Appeal Decision

Decision date: 6th October 2021

Appeal Ref: APP/R5510/D/21/3278178

40 Thurlstone Road, Ruislip HA4 0BT

Proposed Elevations

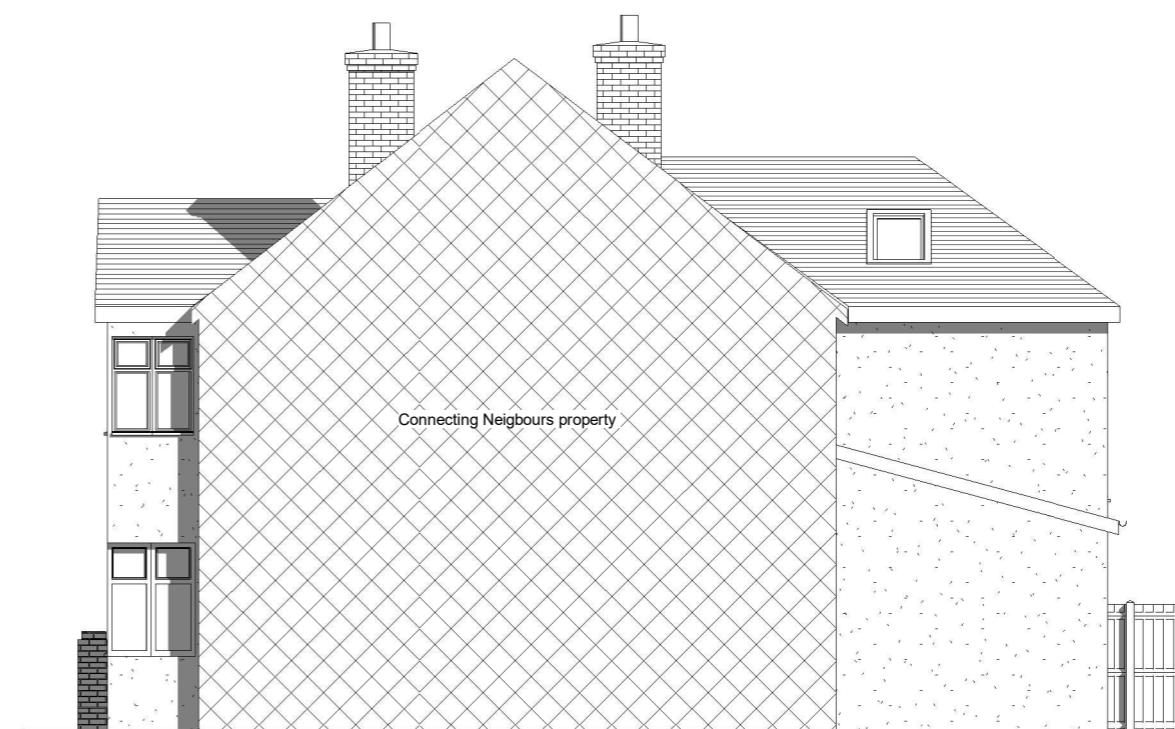
4. The character of the street scene along Thurlstone Road contains some variety to the house types, although they are in the main, arranged in planned blocks. It is also obvious that some end of row houses have been subdivided into further separate residential units.
5. The appeal property is the end dwelling within a row of approximately four houses. Number 34 at the other end of the row is also the same house type and shares the same roof formation above with a staggered ridgeline an original feature of the row.
6. The proposed roof would add considerable mass and bulk to the dwelling and would be highly visible from both the front and side elevations within the street scene. It would not be viewed as subordinate to the host dwelling due to the continuous ridge line that would be created across the dwelling.

7. The proposal would not relate well in design terms to the host dwelling and harmfully imbalance the symmetry that is a feature of this short row of houses given the corresponding roof of No 34. Consequentially, it would not represent high quality design and instead appear as a visually obtrusive form of development to the host dwelling, the row, and detrimentally harmful to the character and appearance of the wider street scene.

14. To conclude, the proposal would result in an uncharacteristic and visually obtrusive development, in particular by virtue of the roof formation and would lead to harm arising to the host dwelling, to the character and appearance of the row of houses, and to the local area. This would be in conflict with the design aims of Policy BE1 of the Hillingdon Local Plan: Part One - Strategic Policies 2012, Policies DMHB 11, DMHB 12 and DMHD 1 of the Hillingdon Local Plan Part Two - Development Management Policies 2020.
